REFUSAL OF PLANNING PERMISSION

APPLICATION NO. 2016/1543

Proposal Erection of detached garage.

At 27 Milton Street, Great Houghton, Barnsley, S72 0AD

PLAN & ELEVATIONS

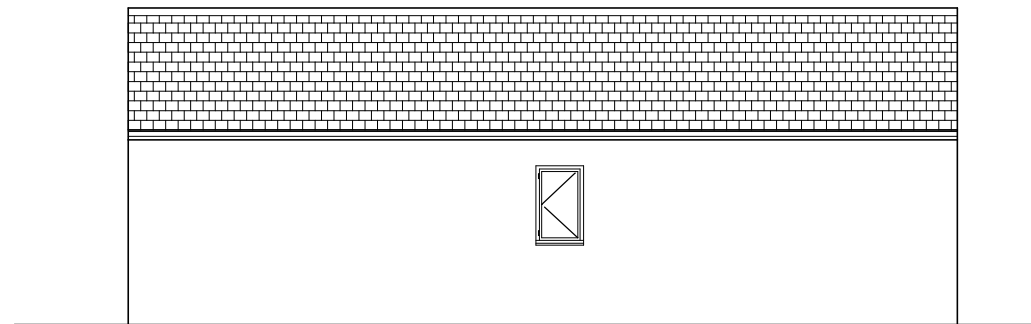
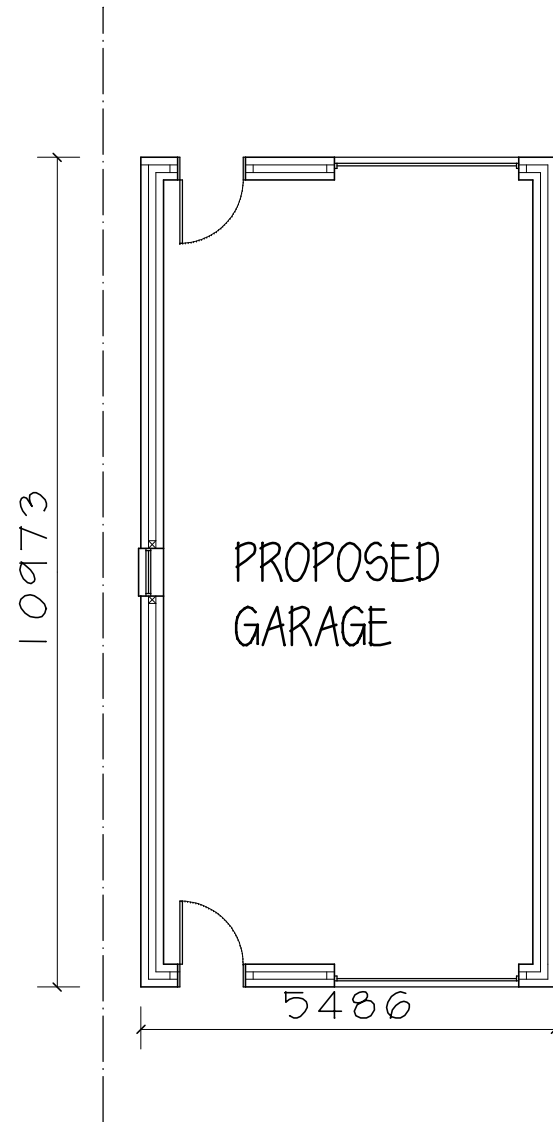
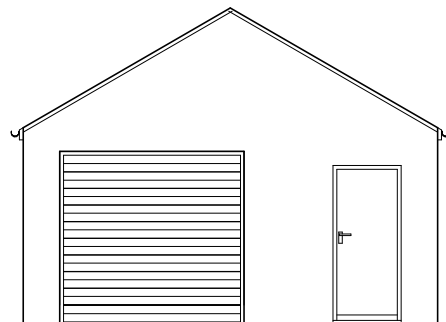
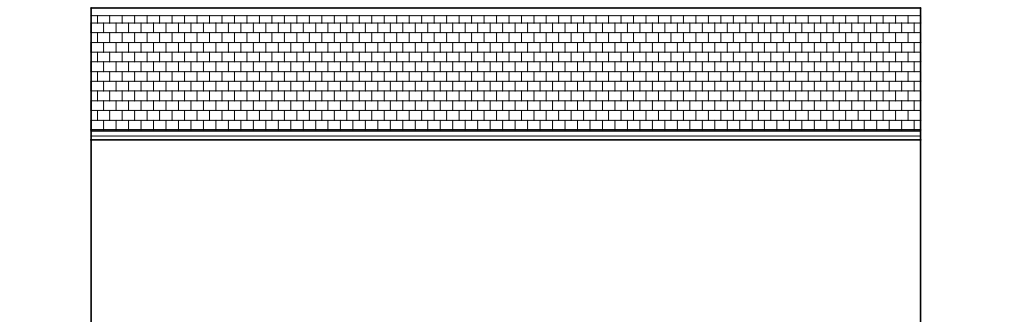
- 1 In the opinion of the Local Planning Authority the proposed garage and workshop building would be contrary to Policy CSP 29 and the Council's Supplementary Planning Document 'House Extensions' in that its design and scale would be at odds with the local context, in particular with the outbuilding having a large footprint in relation to the host property. As a consequence the building would not appear as ancillary to the host property and instead would be a dominant and unduly intrusive feature in the street scene to the detriment of visual amenity.
